**KIRKLEES METROPOLITAN COUNCIL
TOWN AND COUNTRY PLANNING ACT 1990
HIGHWAYS DEVELOPMENT CONTROL KP20H**

PLANNING REF 2016/60/92664/E0/ET
CATEGORY Major

PROPOSAL OUTLINE APPLICATION FOR
ERECTION OF 19 DWELLINGS

LOCATION OAK MILL,
CLIFF HOLLINS LANE,
EAST BIERLEY,
BD12 7ER

Proposed Site Plan

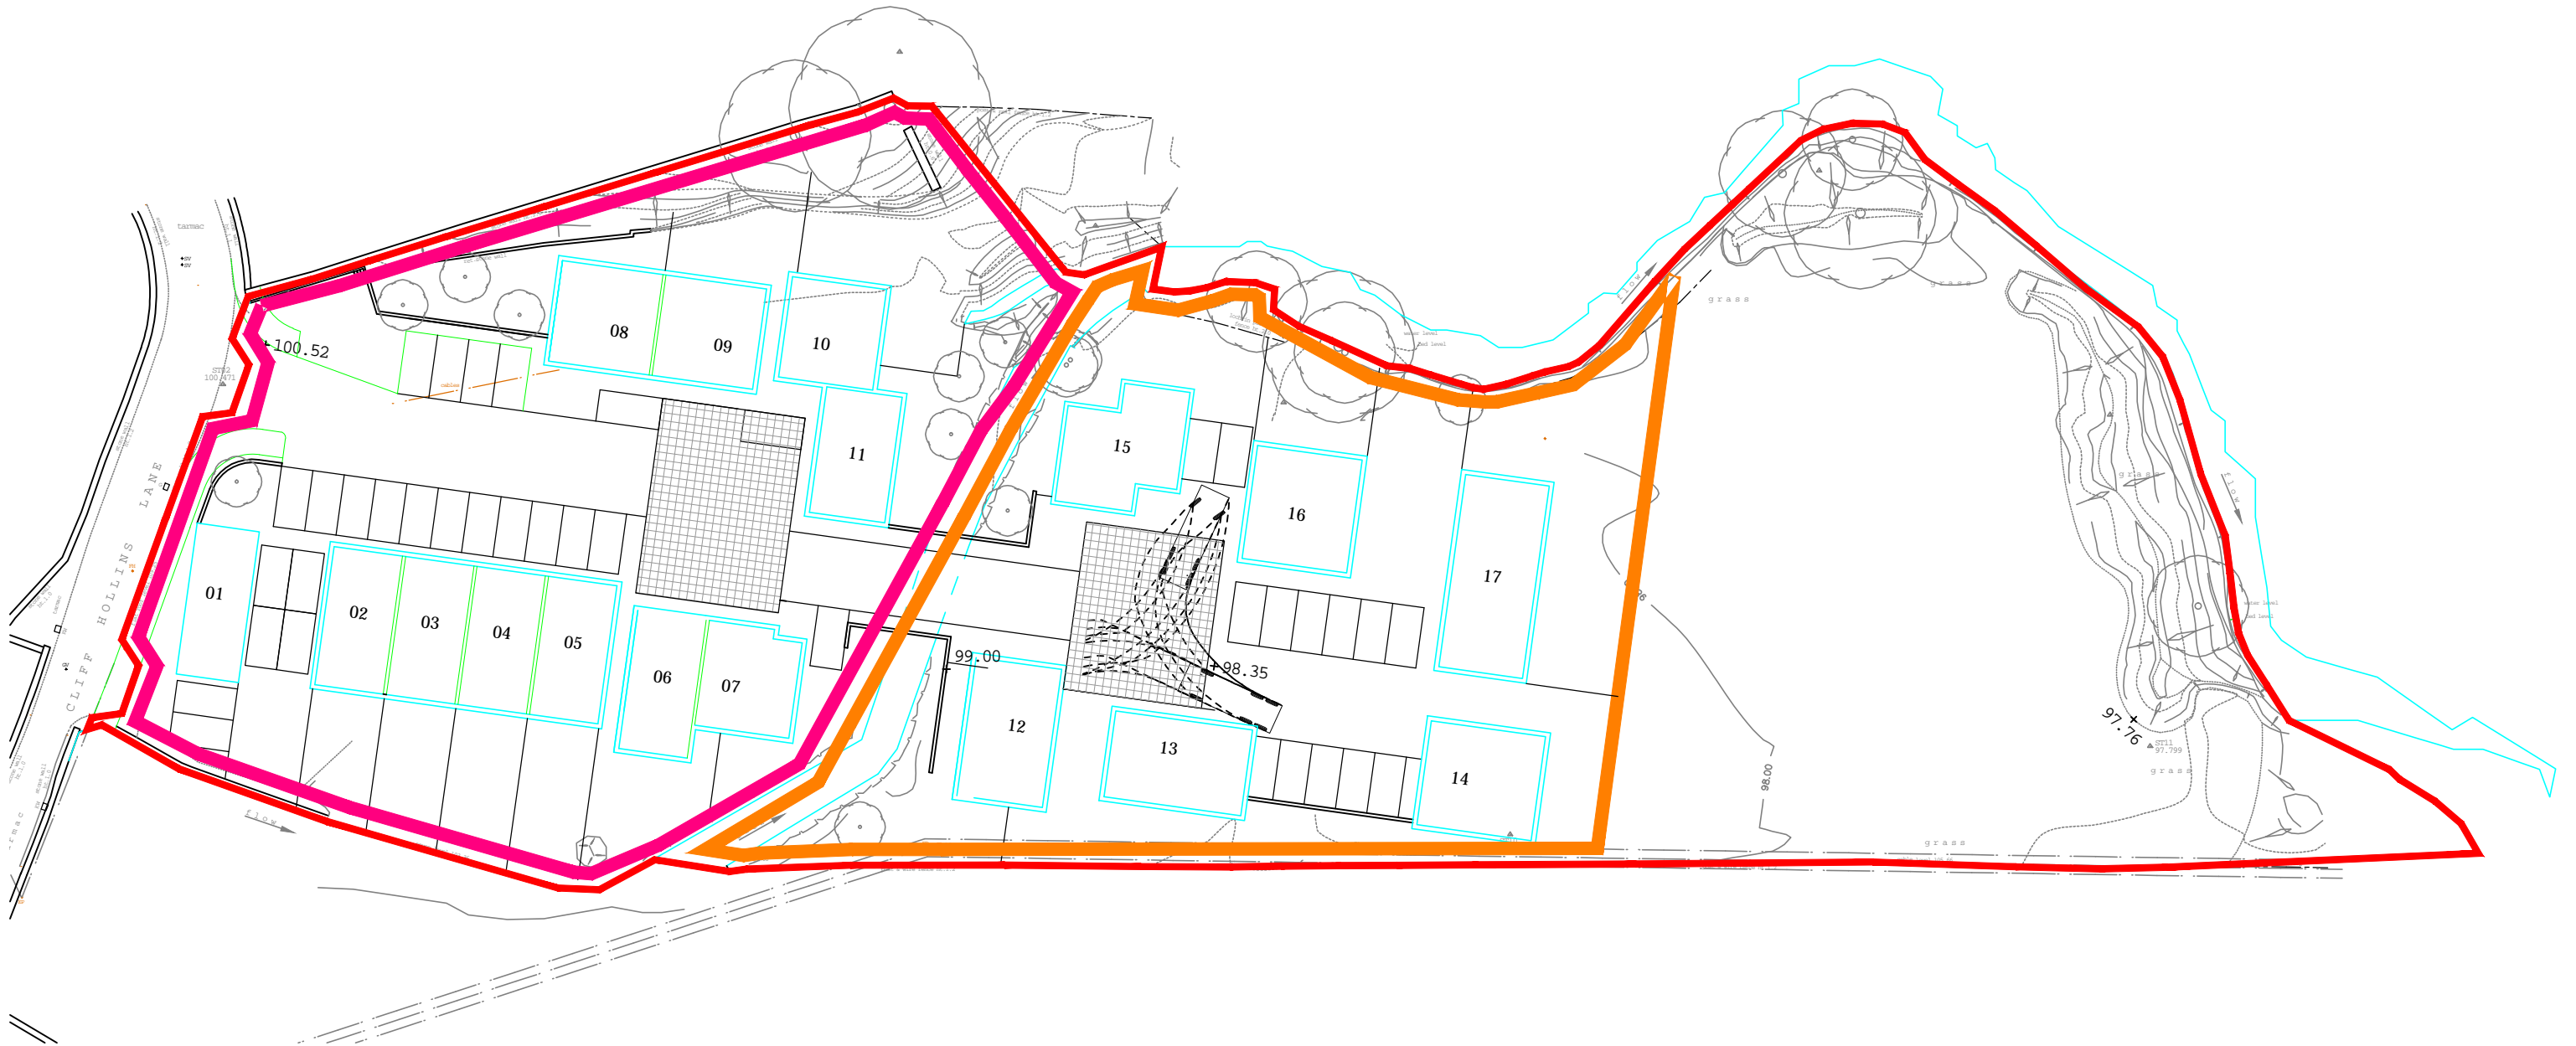
There are 25 existing vehicle parking spaces on the existing site and a total of 37 proposed on the indicative plan.

Footways 2.0 metres in width will need to be provided to the full frontage of the development onto Cliff Hollins Lane and the carriageway widened where necessary to provide a minimum width of 5.5m.

Visibility splays of 2.4 x 43m will need to be shown on the proposed plans from the proposed access onto Cliff Hollins Lane.

In general the layout should be a shared surface designed to achieve a maximum speed of 15-mph, parking should be provided in accordance with Appendix 2 of the UDP, including visitors (1 space per 4 dwellings) and cycle parking. Turning heads should be designed to accommodate an 11.6m long waste collection vehicle which should be demonstrated using swept path analysis. The access road should be 5.5m in width and 600mm hard margins are needed to all sections of any shared surface carriageways.

A water course crosses the site and runs beneath the proposed adoptable highway. An assessing the adequacy of any structure beneath the proposed adoptable road will need to be submitted to, and

approved in writing by, the Council's Highways Structures Section.

The existing gated access onto Cliff Hollins Lane to the eastern side of the site should ideally be closed to reduce the number of points of access along this section of road.
